Application 3/2021/0275

Location: Land behind The Dog Inn, Market Place, Longridge PR3 3RR

Proposal: Proposed erection of 9 new dwellings and associated works

I refer to the latest letter from United Utilities dated 19th June 2024 in which further additional information has been requested to be submitted in support of the application.

Proposed Site Plan
1 : 200
0 1 5 10m

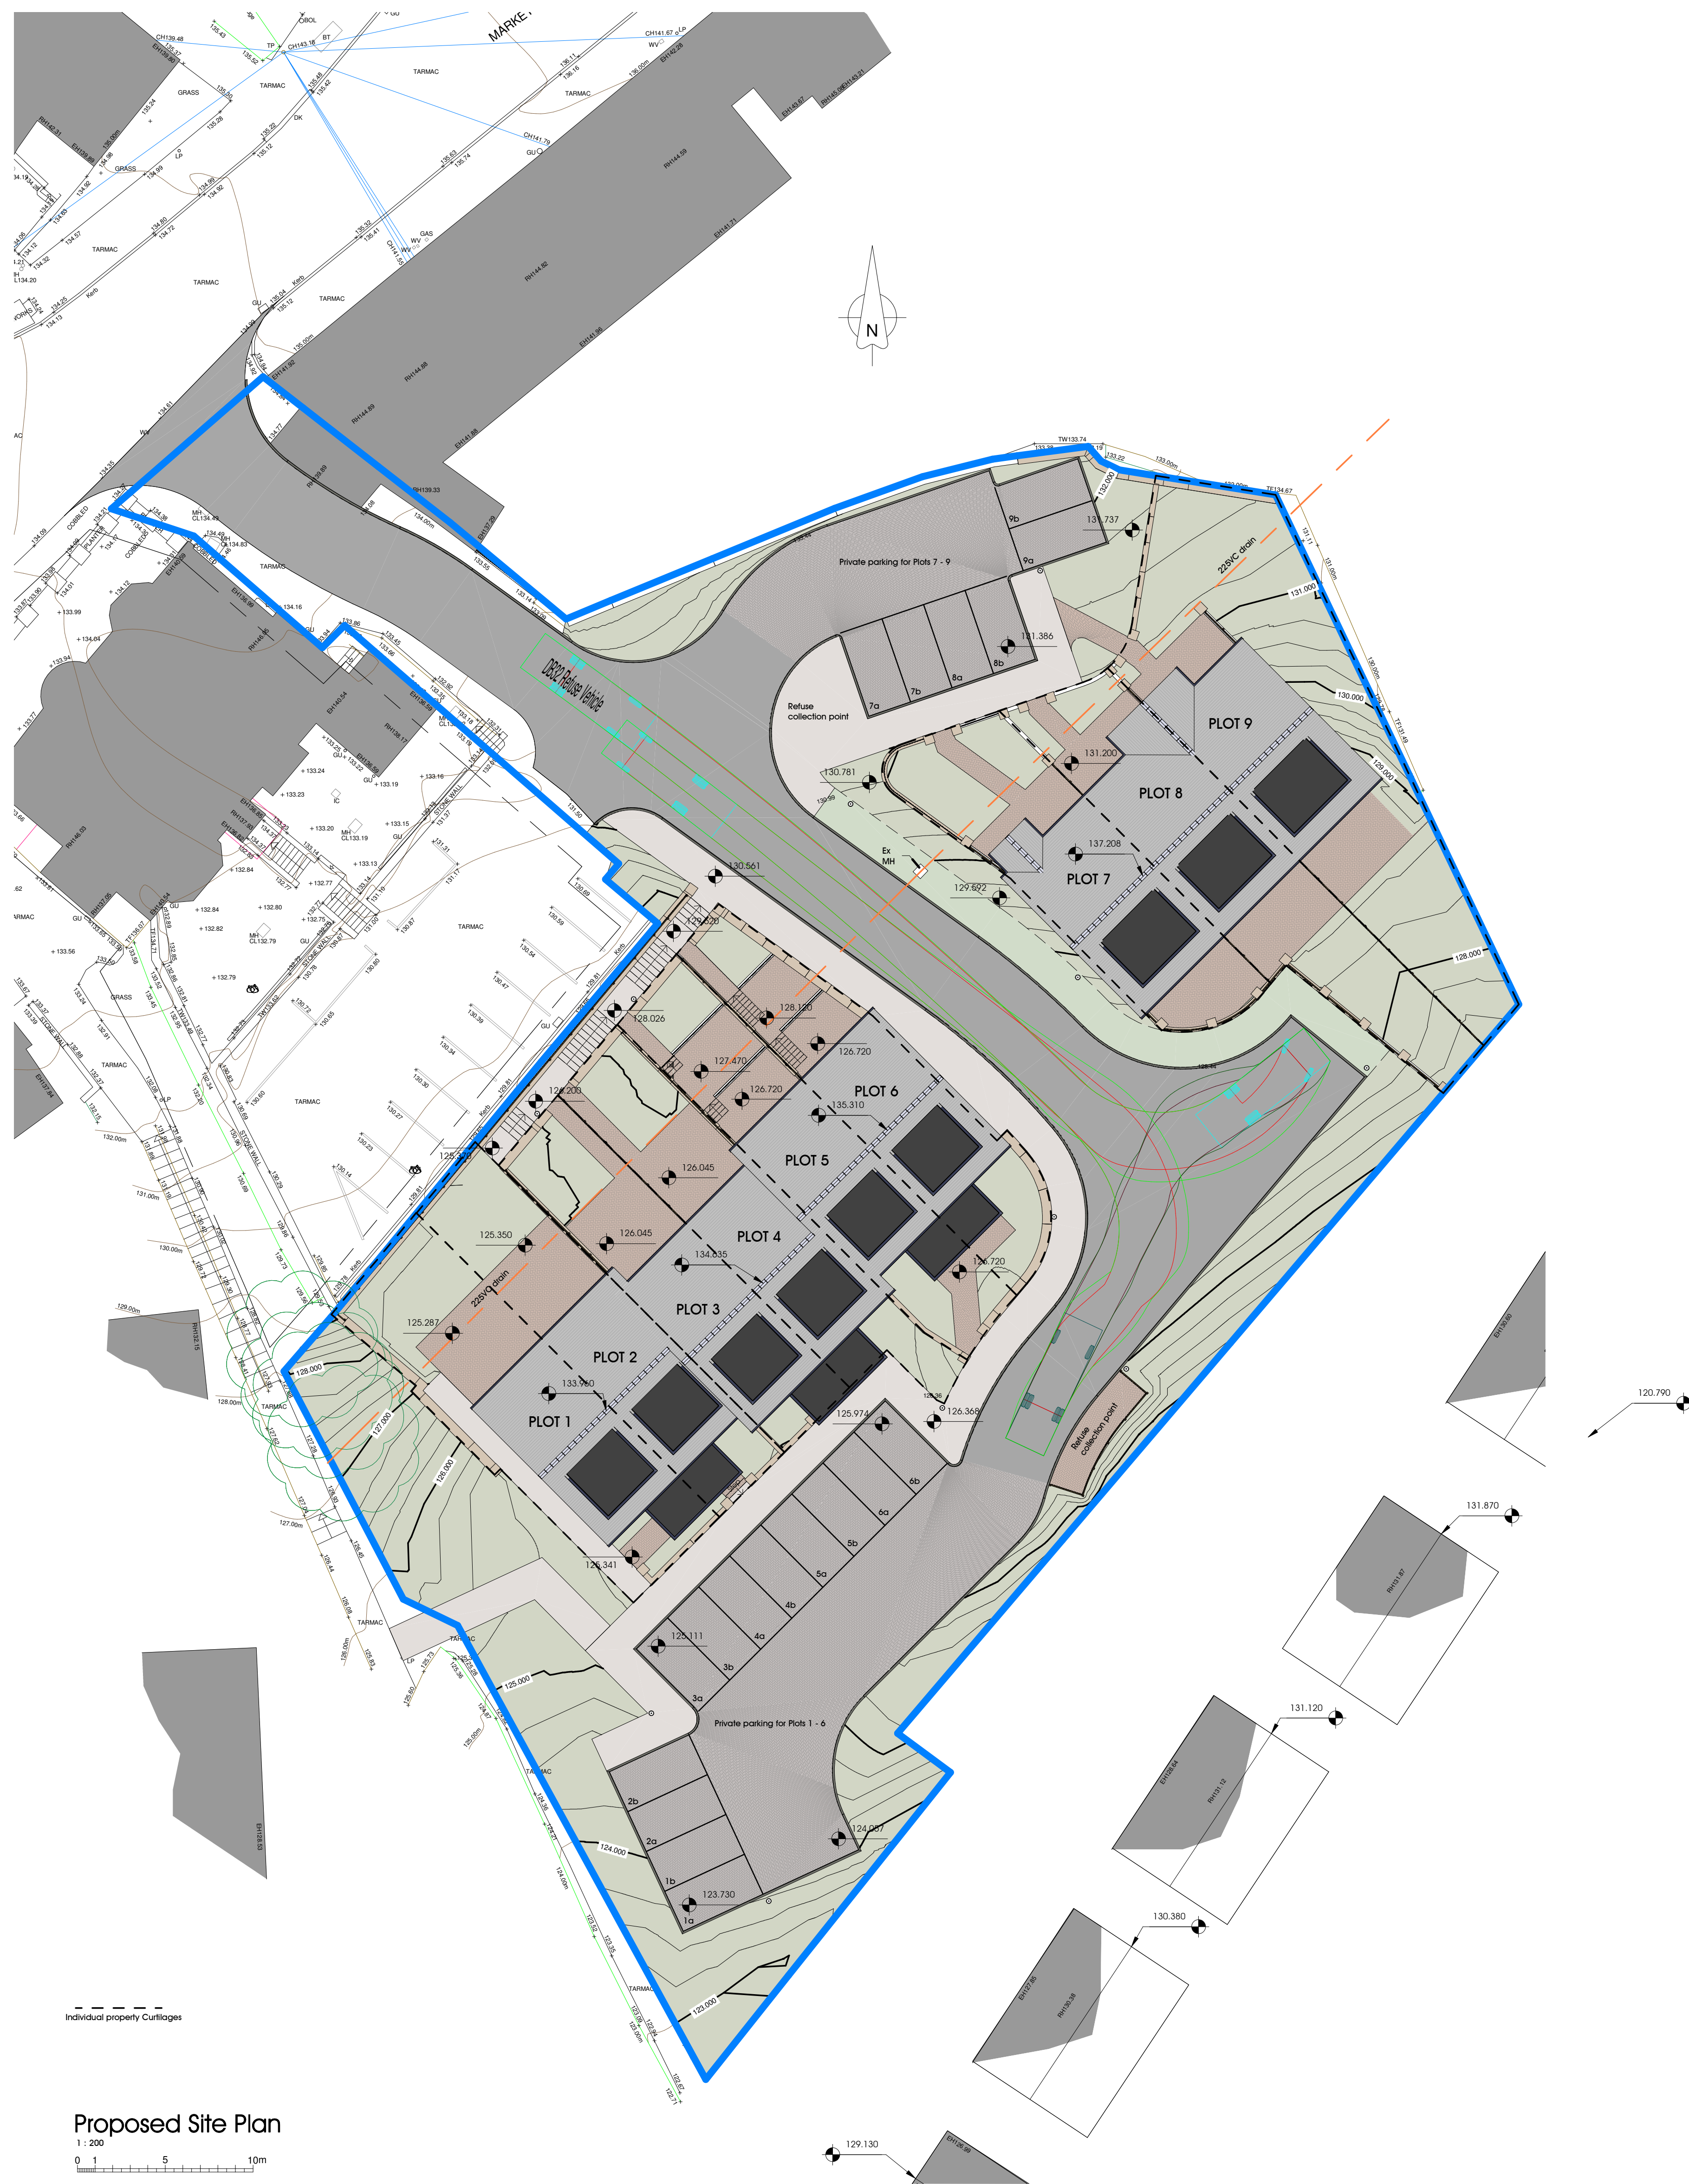
Following our review of the submitted Drainage Strategy, and further to the previous comments we have provided in relation to this application, we note that exceedance flow paths have been shown for the proposed new manhole on the western boundary of the site, however it does not include overland flow paths from the existing manhole MH6102. The cover level for MH6102 is 127.157 AOD however the proposed finished flood levels for Plots 7 and 8 are 126.404 AOD. We request that the applicant confirms the flood exceedance path from this manhole and, if required, includes measures to ensure that Plots 7 and 8 are not at risk of flooding from the existing manhole, including raising finished floor levels and / or mitigation measures / features to ensure the properties are not at risk of flooding. Noting this is a full

application, and site levels and finished floor levels are intrinsically linked to the proposed site layout, we request that updated information is submitted for our review and comment prior to the determination of this application.

In order to prevent any exceedance flows from United Utilities manhole 6102, it is proposed to extend the boundary wall of Plot 8 along the western elevation to direct any exceedance flows away from Plots 7 and 8 thus ensuring that Plots 7 and 8 will not be at risk of flooding from the manhole. The drainage drawing showing the location of the wall is attached to this letter.
